**Planning Department
Transportation Development Services Section**

Re: **Certification for a Permanent Building Certificate of Occupancy (C.O.)**
Garcia's Kitchen, [J-20/D008]
8518 Indian School NE
Engineer's Stamp Dated 08/13/12

Re: **Certification for a 60-Day Temporary Building Certificate of Occupancy (C.O.)**
Garcia's Kitchen, [J-20/D008]
8518 Indian School NE
Engineer's Stamp Dated 06/21/12

Re: Garcia's Kitchen, 8518 Indian School Rd NE, Traffic Circulation Layout
Engineer's Stamp dated 02-14-12 (J20-D008)

TRAFFIC CIRCULATION LAYOUT APPROVED
Signed: [Signature] Date: 03-01-12

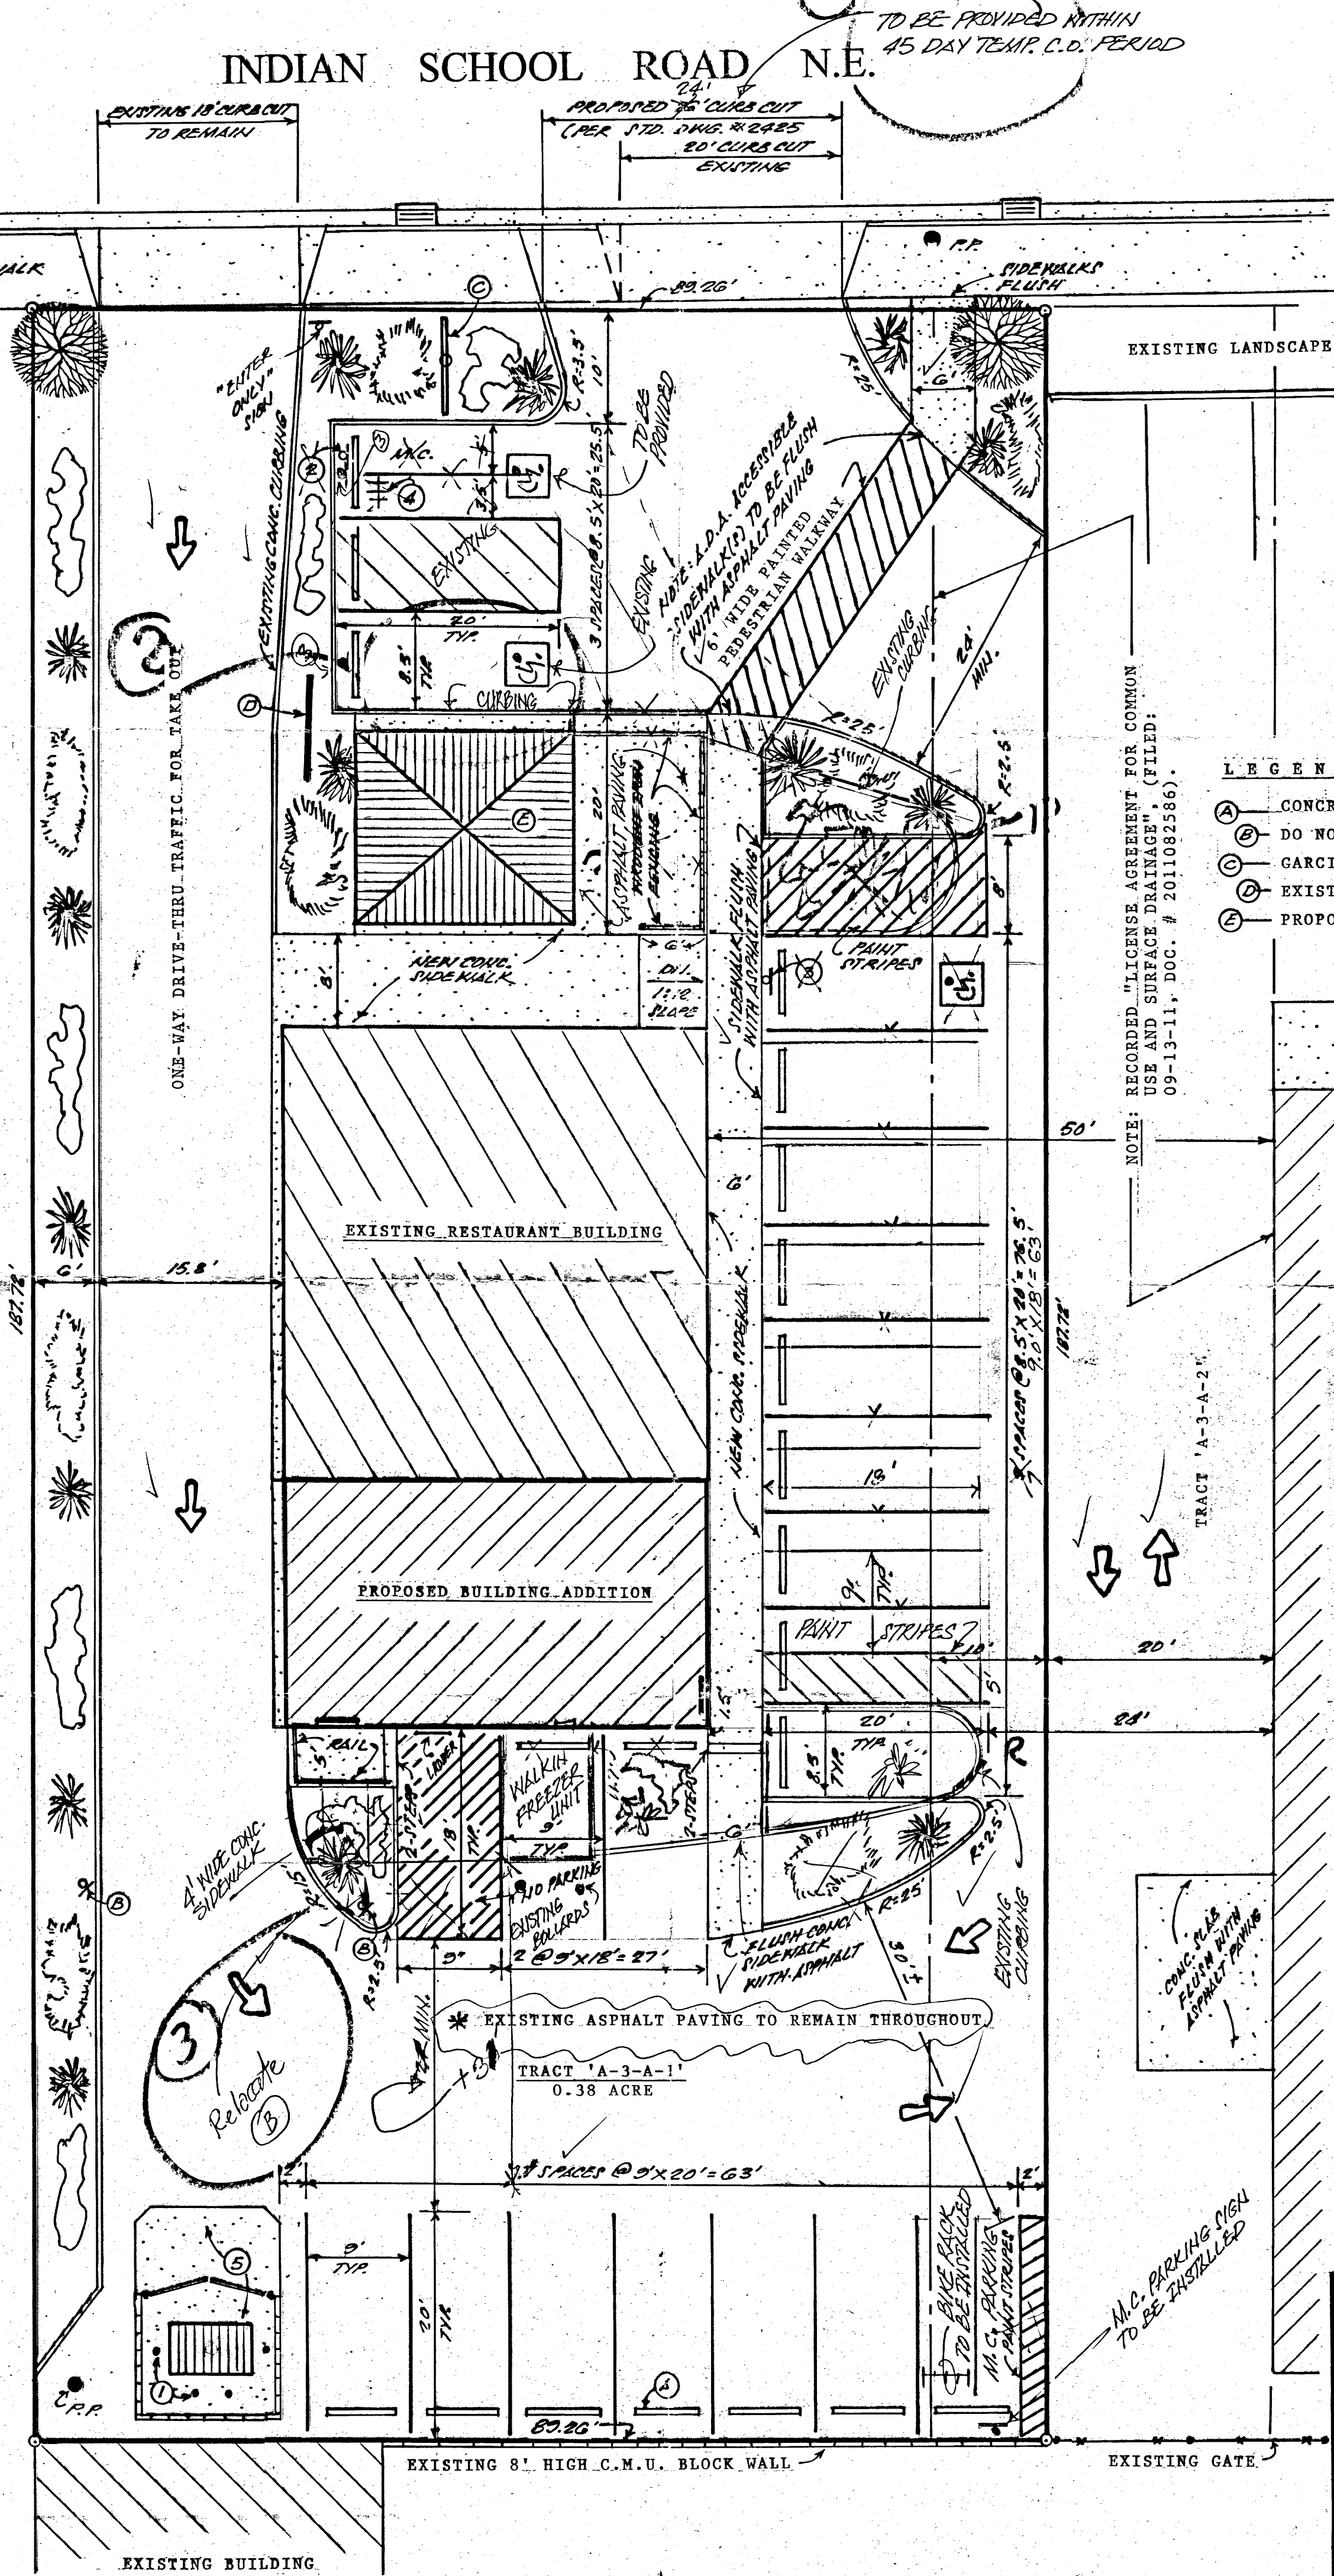
- Provide 24-foot curb cut at Indian School entrance.
- Relocate van accessible aisle to Canopy Patio curbing and provide pavements marking to delineate accessible route from aisle to site.
- Relocate 'Do Not Enter' sign to proposed 4-foot conc. sidewalk curbing.

- Provide 24-foot curb cut at Indian School entrance.
- Relocate van accessible aisle to Canopy Patio curbing and provide pavements marking to delineate accessible route from aisle to site.
- Relocate 'Do Not Enter' sign to proposed 4-foot conc. sidewalk curbing.

- 1.) a 24' curb cut has been provided at the Indian School
Road N.E. entrance.
- 2.) relocated van accessible aisle to canopy patio and provided
pavement markings to delineate accessible route from aisle
to site building.
- 3.) provided "DO NOT ENTER" sign to proposed 4' concrete side-
walk curbing.

DRAINAGE PLAN

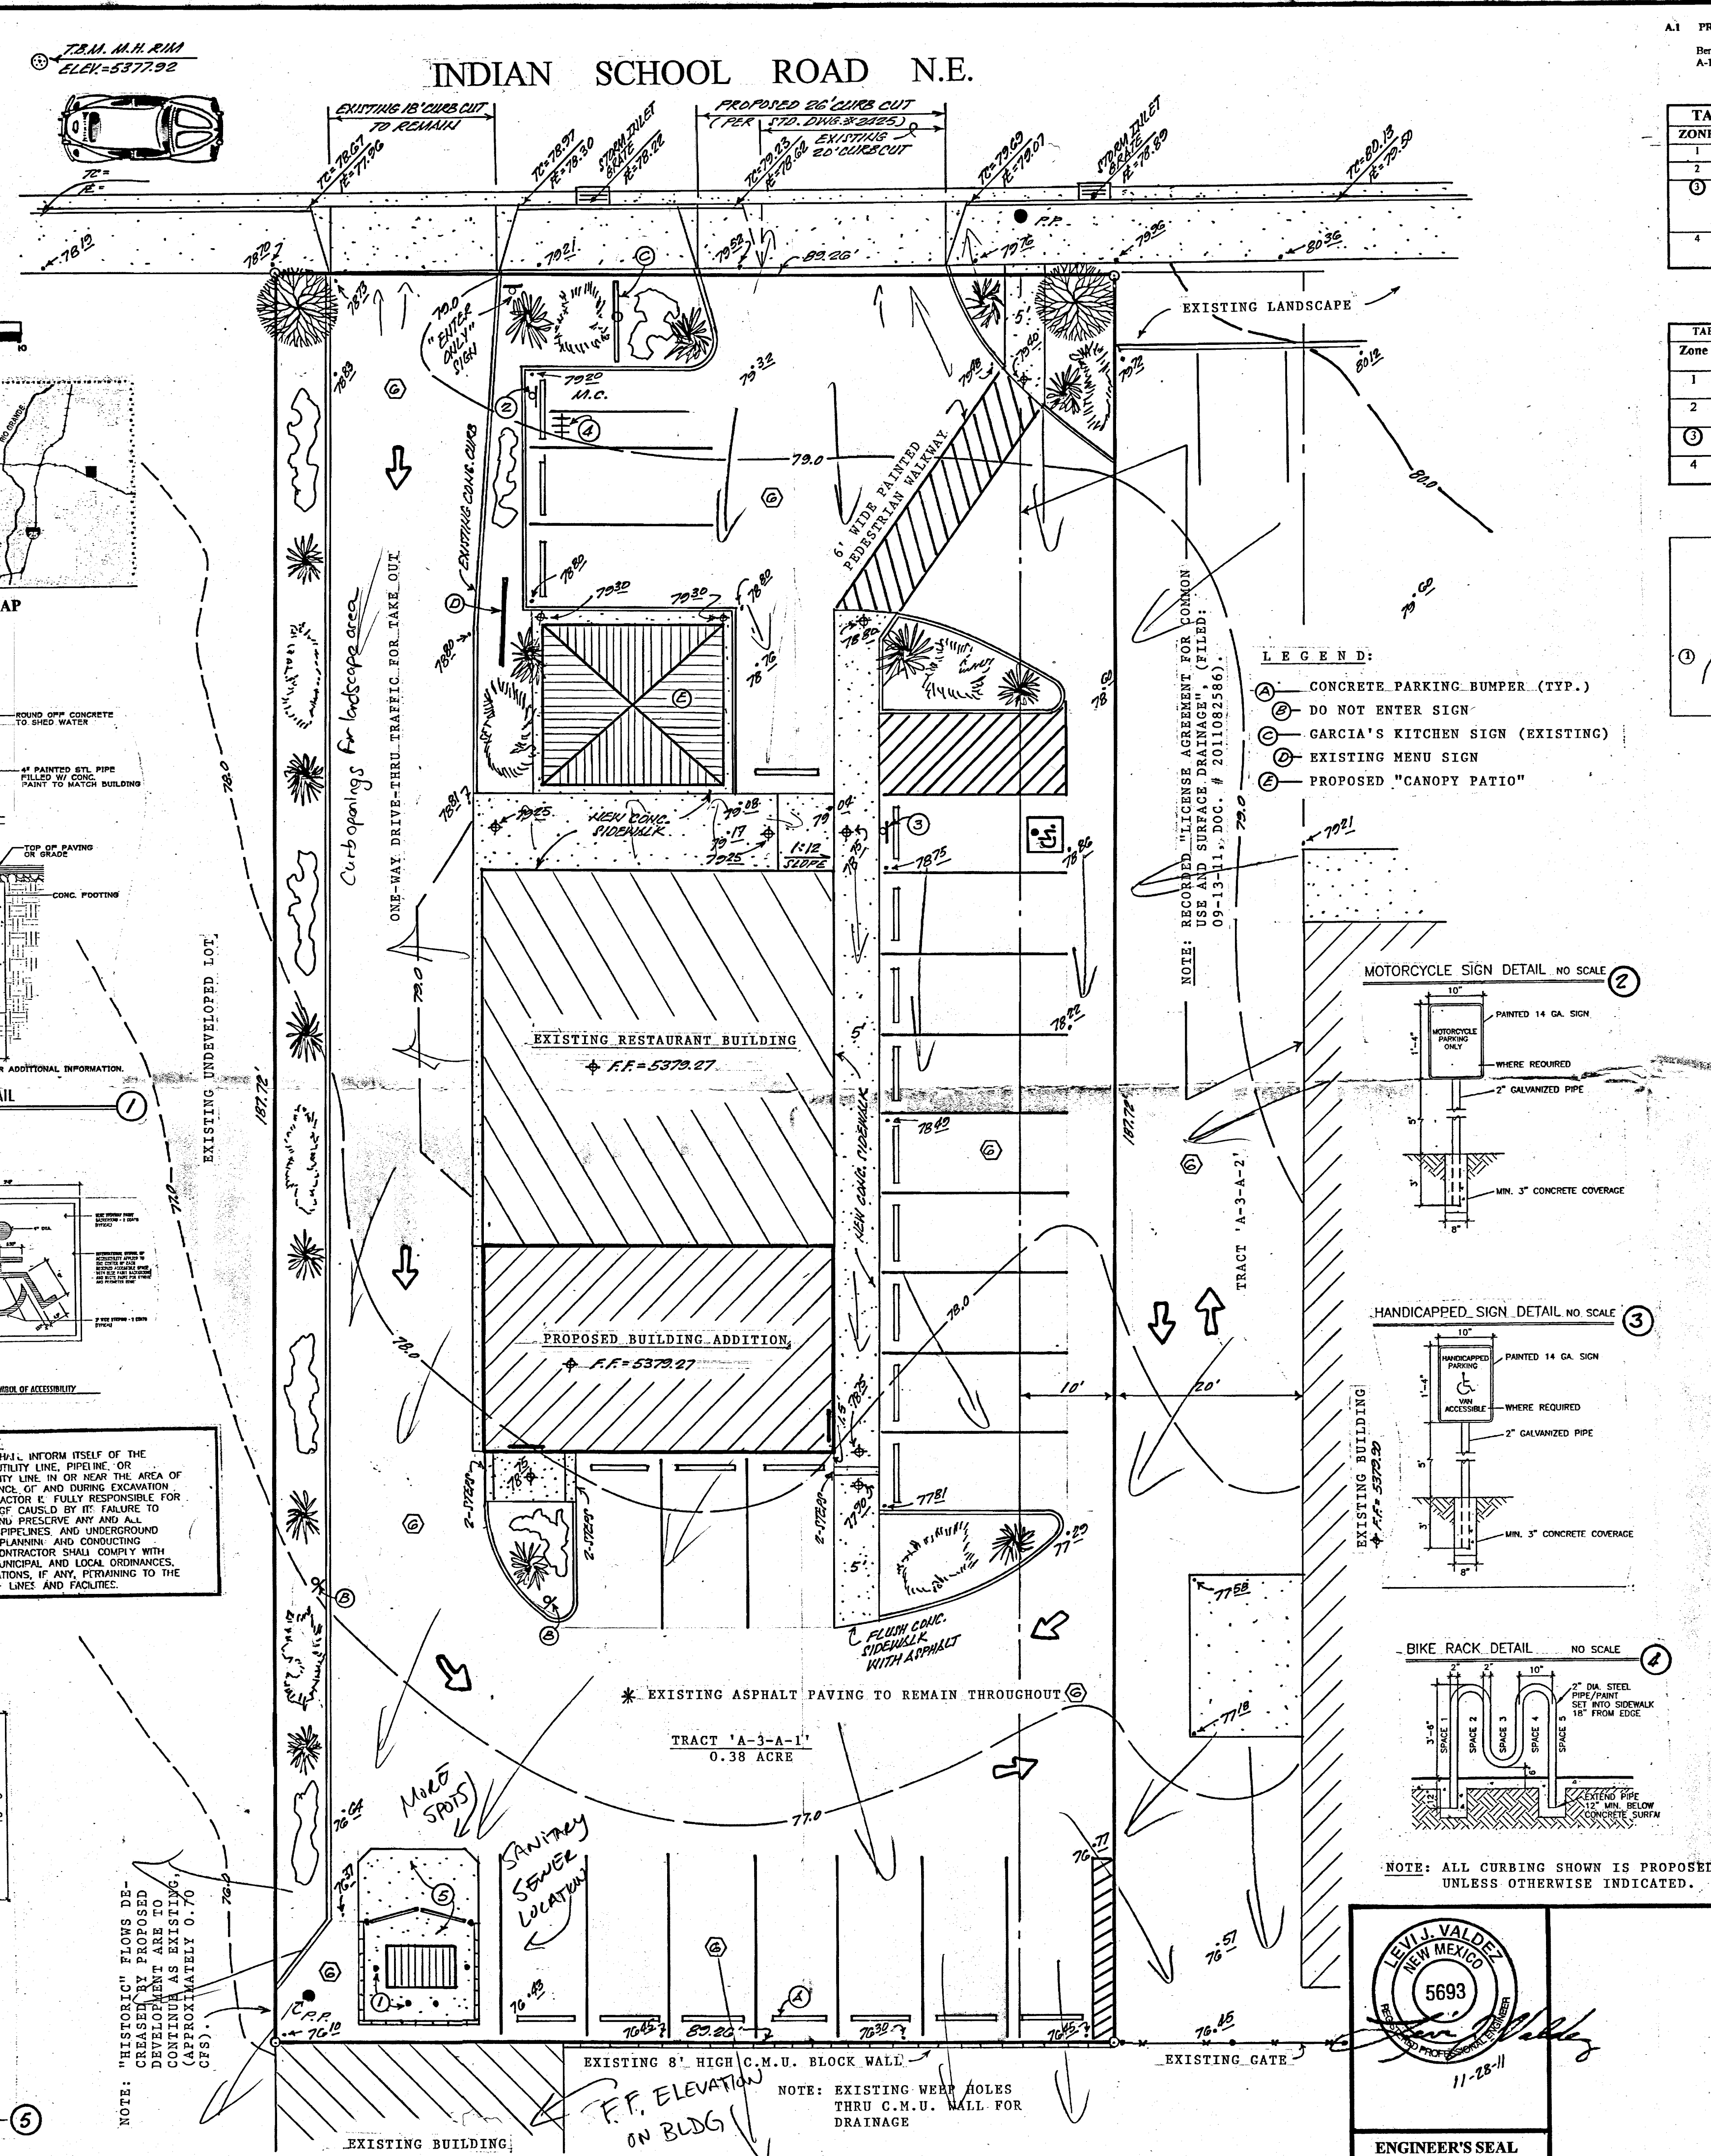
- Hydrology is requesting that you depress all landscaped areas for water harvesting.
- The concrete curb that runs along the western property line should include curb openings to allow for sheet flows into the landscape areas.
- Provide additional spot elevations around the trash enclosure.
- Plan must show the location of the drain connection for the trash enclosure.

TRAFFIC CIRCULATION LAYOUT
FOR
GARCIA'S KITCHEN
(8518 INDIAN SCHOOL ROAD N.E.)
ALBUQUERQUE, NEW MEXICO
OCTOBER, 2011

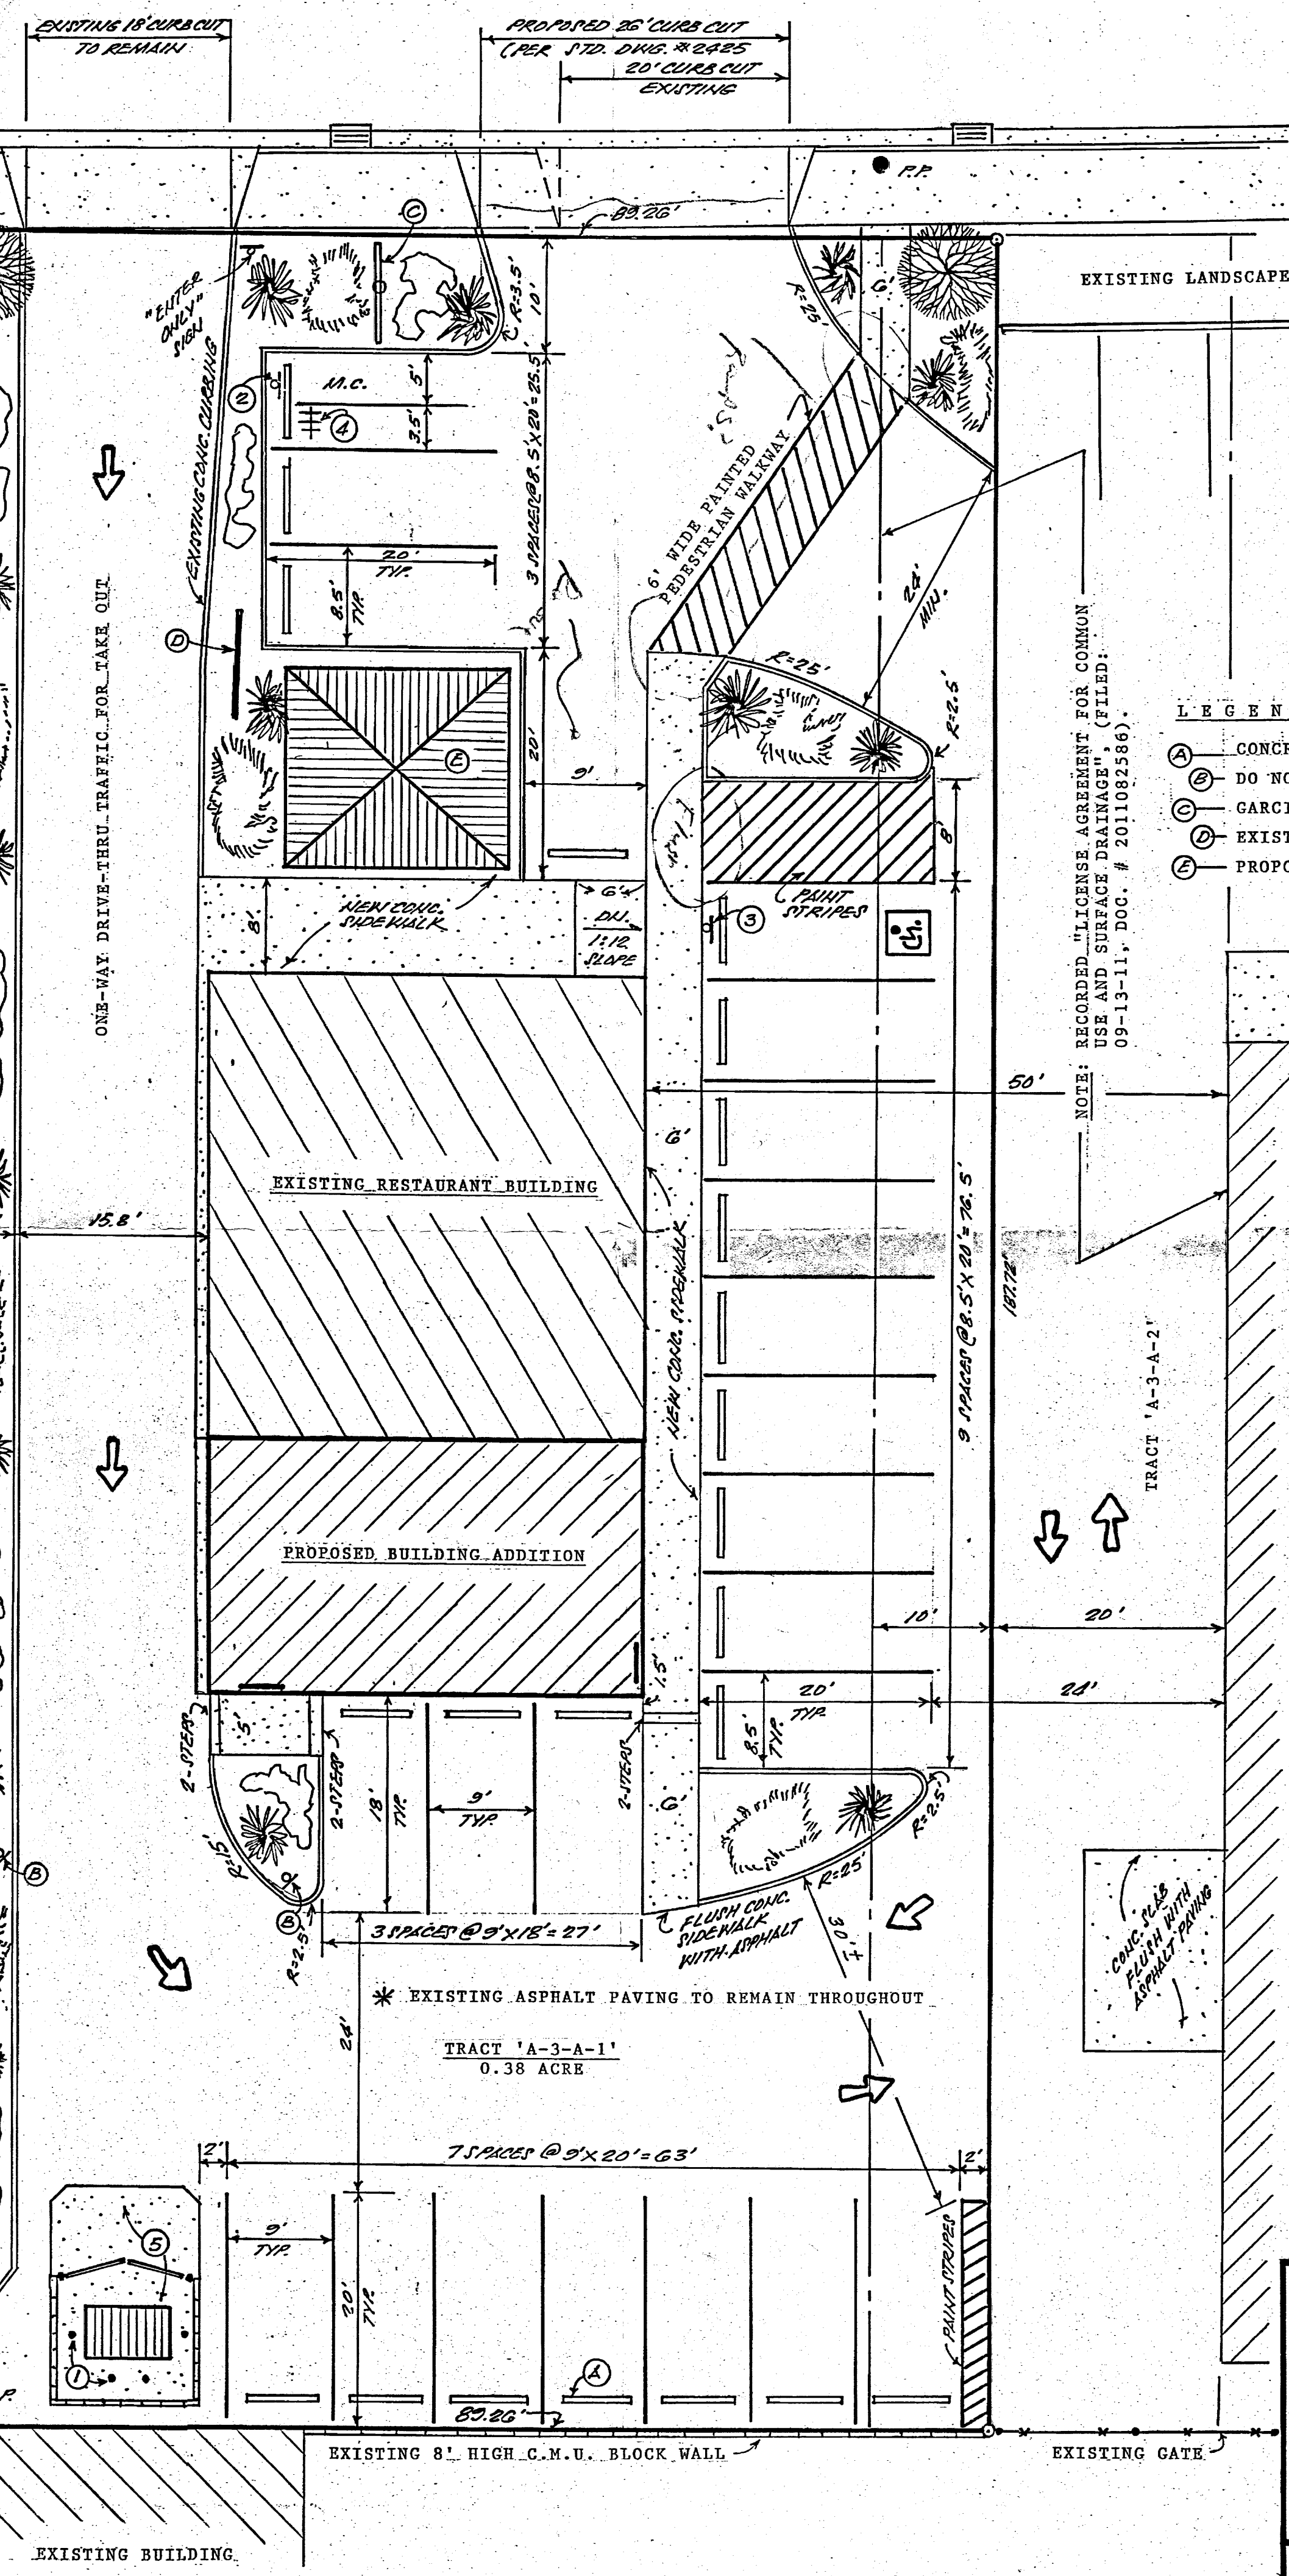
1. Clearly show the ADA accessible pathway from the public sidewalk to the building. Show all ramps or note flush elevation.
2. The parking stall located directly east of the "Canopy Patio" is not provided with adequate maneuverability to safely operate. Please remove this parking stall.
